The Planning Inspectorate Yr Arolygiaeth Gynllunio

Application by AQUIND Ltd for the AQUIND Interconnector

The Examining Authority's further written questions

Plate 5 – Typical Schematic of Joint Bay (distances in millimetres)

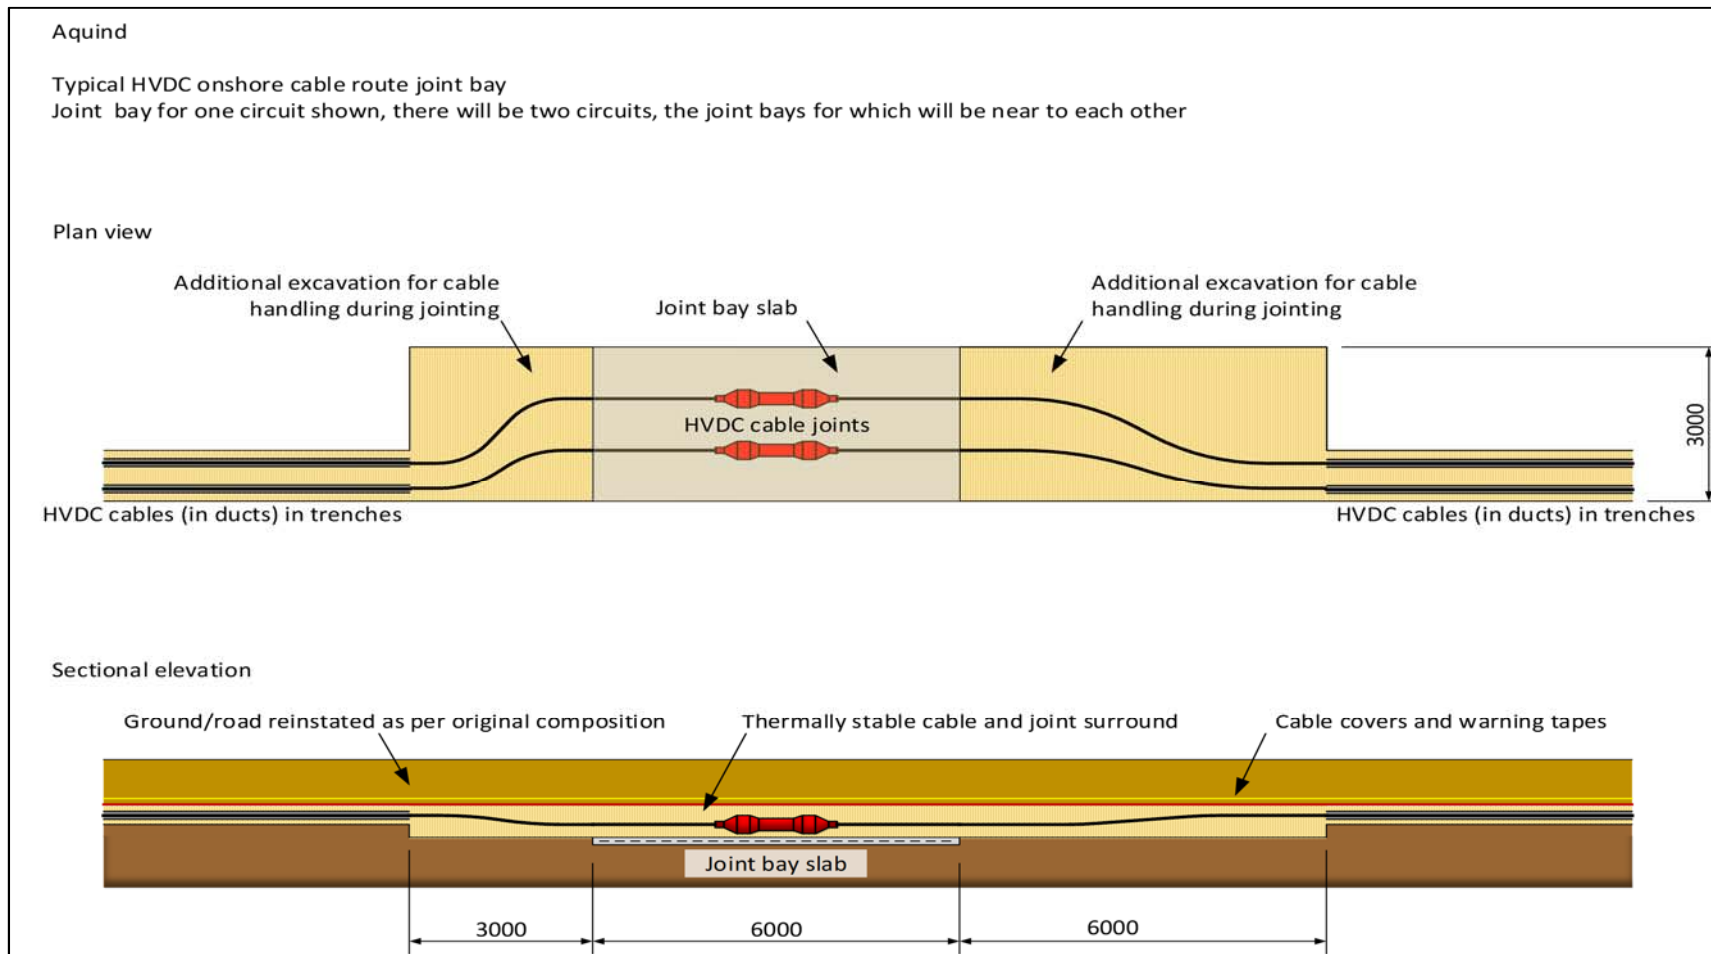
Reference	Respondent(s)	Question	
		Technical Note, notwithstanding any perceived limitations in the modelling. If not, why not?	
TT2.16.7	Applicant	<p>The Joint Bay Technical Note [REP6-070] shows indicative locations for joint bays. Whilst it is acknowledged these are indicative and there are more shown than is permissible in the dDCO, the ExA notes that JB's 11, 12, 13, 14, 15, 16, 18 and 19 in particular appear to be within the highway (where the definition of 'highway' incorporates the carriageway and footpath and cycle path margins). It says in APP-137 paragraph 22.4.7.15 that joint bay locations have been included, all of which provide adequate space for construction works to take place without blocking the carriageway. Can the Applicant therefore explain:</p> <ol style="list-style-type: none"> 1) Whether the single-lane closures or shuttle-system for traffic would constitute traffic management for which there should be no more than 6 occurrences on the network at any one time? 2) What arrangements would be in place for the diversion of pedestrians or cyclists during the 20-day joint bay construction period? 3) Have measurements been carried out along the Order limits to confirm that sufficient room (either 40m x 5m in the case of a single bay or 40m x 12.5m in the case of a double bay as shown in [REP6-064]) exists at all potential joint bay locations to confirm that the joint bay will not be in the carriageway?

Plate 6 - Proposed construction traffic management on Day Lane - will be replaced with full page image when issued as PDF

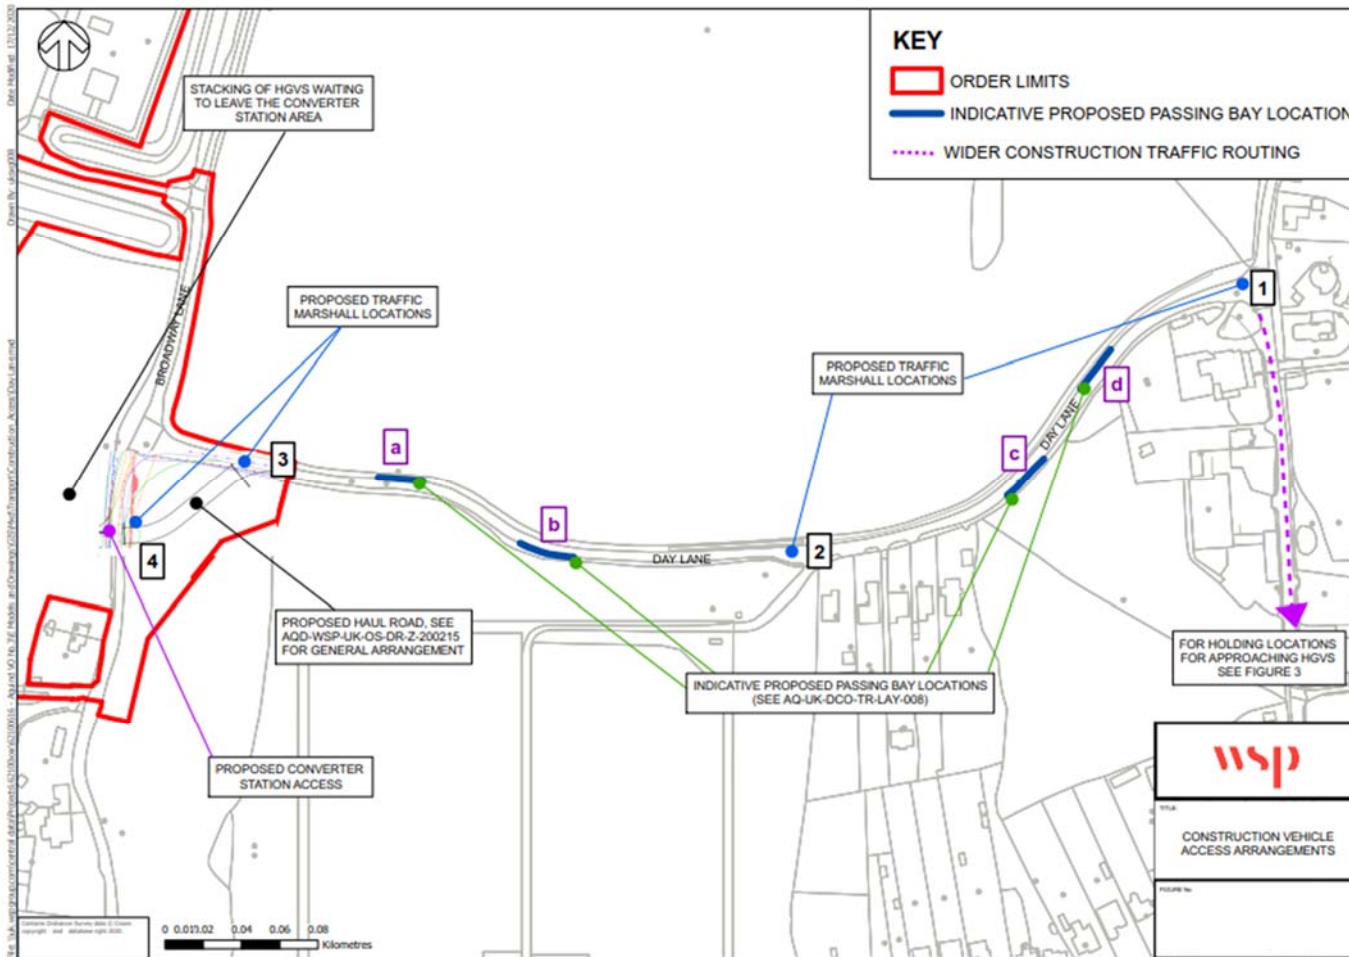
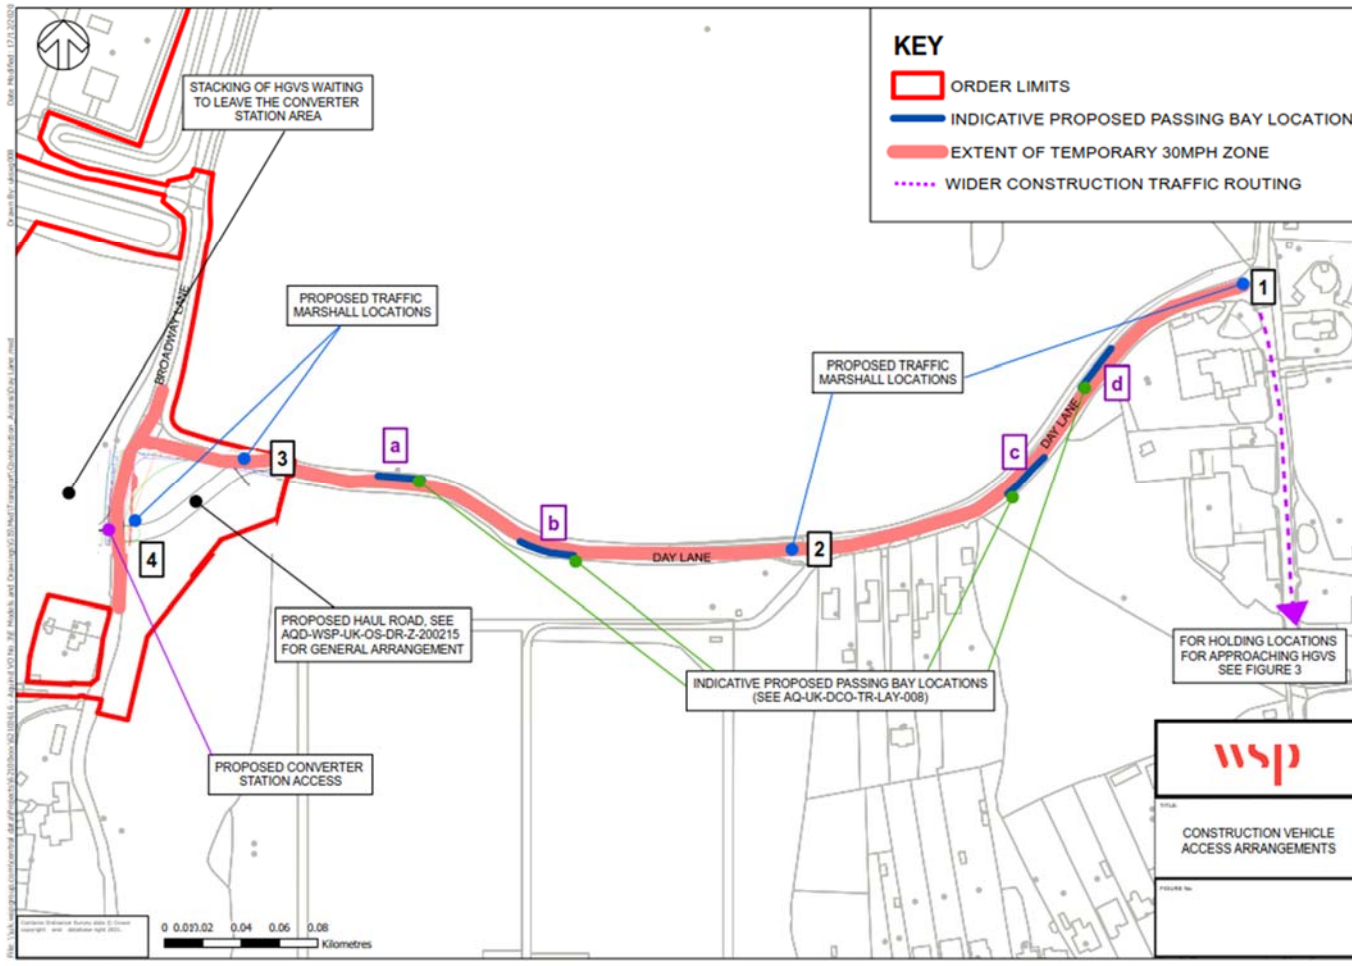
TT2.16.8	Applicant Hampshire County Council	It is proposed to use four passing bays in Day Lane to allow construction-related HGVs to pass non-project traffic and non-related HGVs, and images have been provided showing the locations in the <i>Day Lane Technical Note</i> [REP6-073]. These passing bays appear to be beyond the Order limits and the document does not describe how the bays would be secured or surfaced. Would this be this through a s278 agreement?

Reference	Respondent(s)	Question	
		<p>What evidence exists that all the land for the passing bays is within the public highway?</p> <p>What baseline evidence is there regarding the use, availability and environmental effects arising from the use of these parcels of land for passing bays?</p> <p>What surfacing would be used and how would this impact trees, hedgerows and wildlife?</p>	
TT2.16.9	Highways England	The Applicant proposes using lay-bys on the strategic road network to hold construction-related HGVs temporarily until such HGVs are given the authorisation by a traffic marshal to travel and approach the Converter Station construction site. Can Highways England confirm if the identified lay-bys shown in the applicant's <i>Day Lane Technical Note</i> [REP6-073] have capacity for such vehicles to park and wait and if there are any safety or capacity concerns with the use of the lay-bys in this way?
